**KIRKLEES METROPOLITAN COUNCIL
INVESTMENT & REGENERATION SERVICE**

DELEGATED DECISION TO DETERMINE PLANNING APPLICATIONS

Reference No:	2023/62/92383/E
Site Address:	11, Moorside Court, Moorside, Cleckheaton, BD19 6AY
Description:	Erection of two storey and single storey rear extension and associated external works
Recommending Officer:	Edward Cheseldine

Officer Report

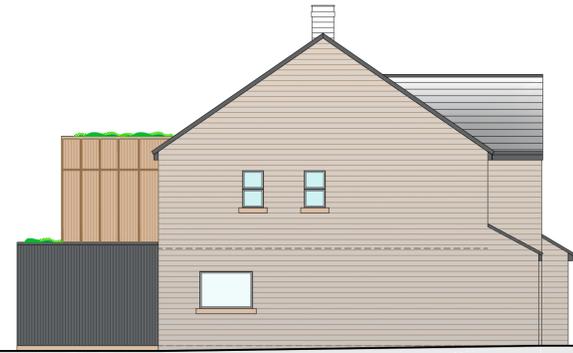
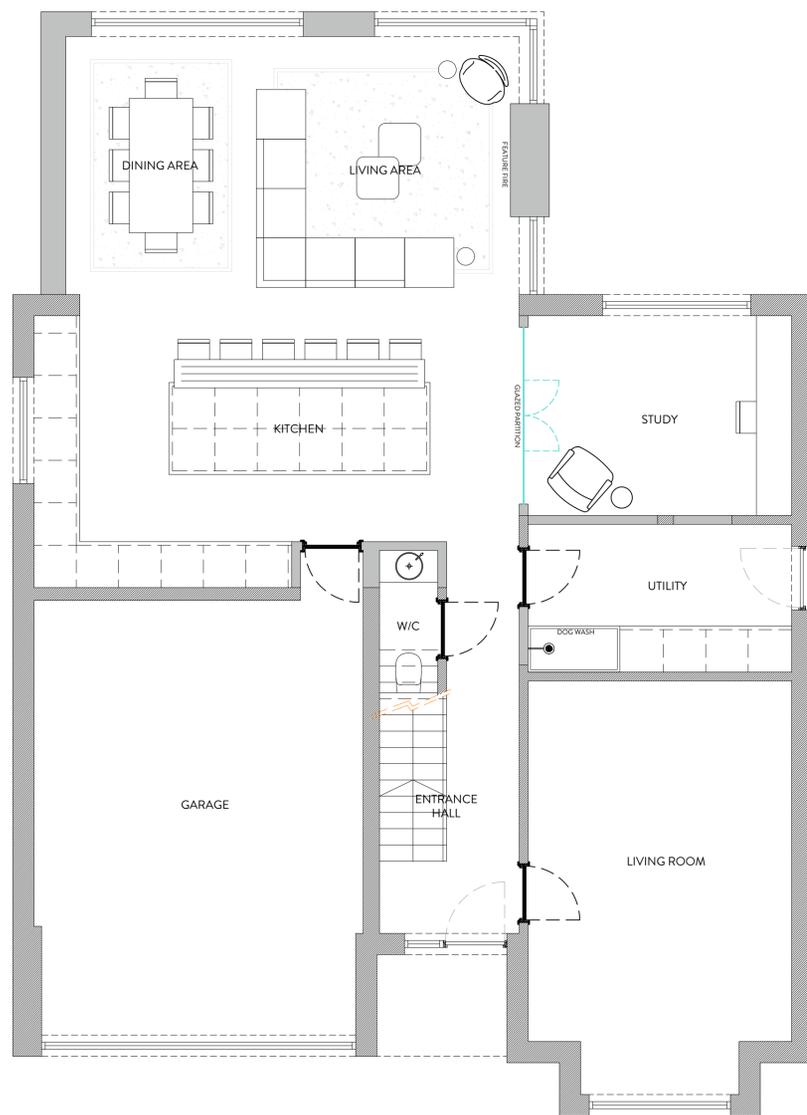
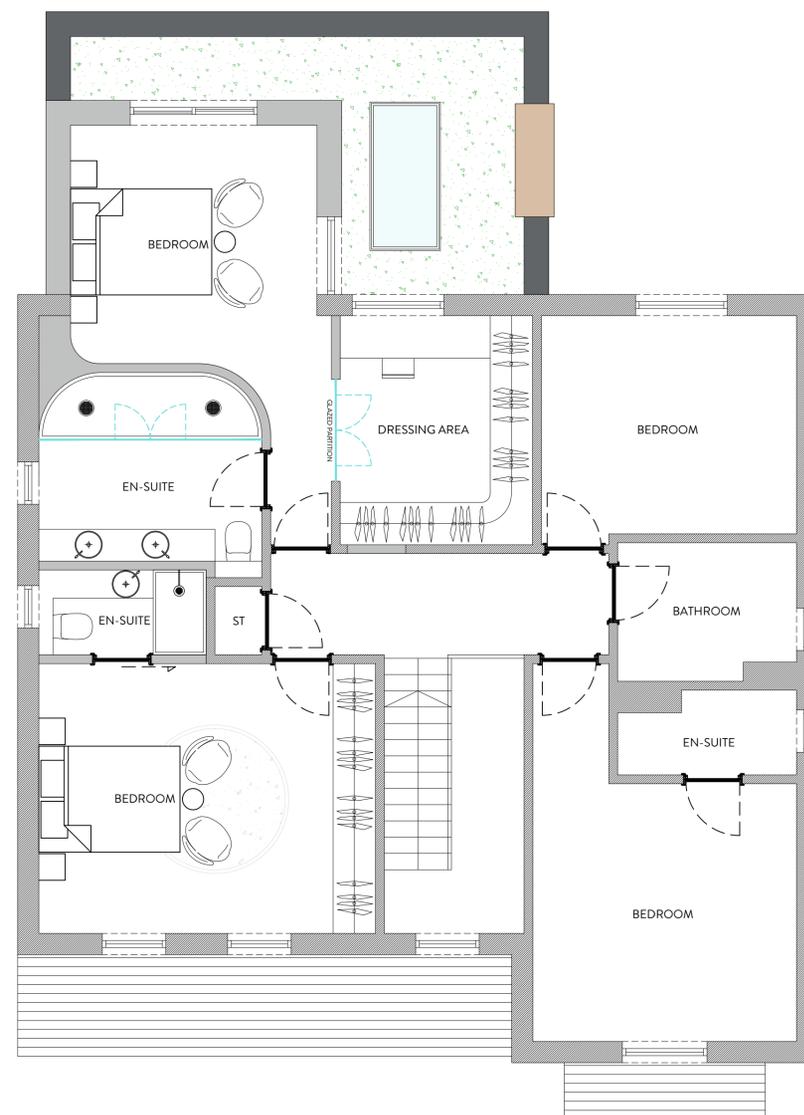
Amended designs were requested by the planning officer in order to reduce the impact of the proposed extensions. The new designs were found to be policy compliant in terms of visual and residential amenity, reducing the harm to neighbouring residents.

In terms of privacy there will be new side facing windows on the ground and first-floor. To ensure privacy, the first-floor side window will be obscurely glazed. Due to the obtuse angle of the windows, boundary treatment and change in elevation to the first-floor windows of No.15 any loss of privacy will not be material when taking into account the positioning and relationship of existing windows to the neighbour and, as such, in this instance acceptable. The terrace originally shown on the plans has been removed.

House Extensions and Alterations Supplementary Planning Document, as well as through design amendments such as reducing the height of the extension and removing the balcony.

Pursuant to article 35 (2) of the Town and Country Planning (Development Management Procedure) Order 2015 and guidance in the National Planning Policy Framework, the Local Planning Authority has, where possible, made a pre- application advice service available, complied with the Kirklees Development Management Charter 2015 and otherwise actively engaged with the applicant in dealing with the application. Amendments were sought to minimise the impact of the development, including reducing the height of the extension, reinstate a 1.50m gap to the boundary and removing the balcony.

2. The development shall not be occupied until the proposed first-floor side windows to the east side elevation (including the bathroom, ensuite and bedroom of the extension hereby approved) have been obscurely glazed (to a minimum Grade 4). The development shall not be occupied until the proposed first-floor windows in the west side elevation (including the two ensuite) of the dwelling hereby approved have been obscurely glazed (to a minimum Grade 4). Notwithstanding the provisions of the Town and Country Planning (General Permitted Development) Order 2015 as amended (or any Order revoking or re-enacting that Order) the obscure glazing (to a Grade 4) shall thereafter be retained.
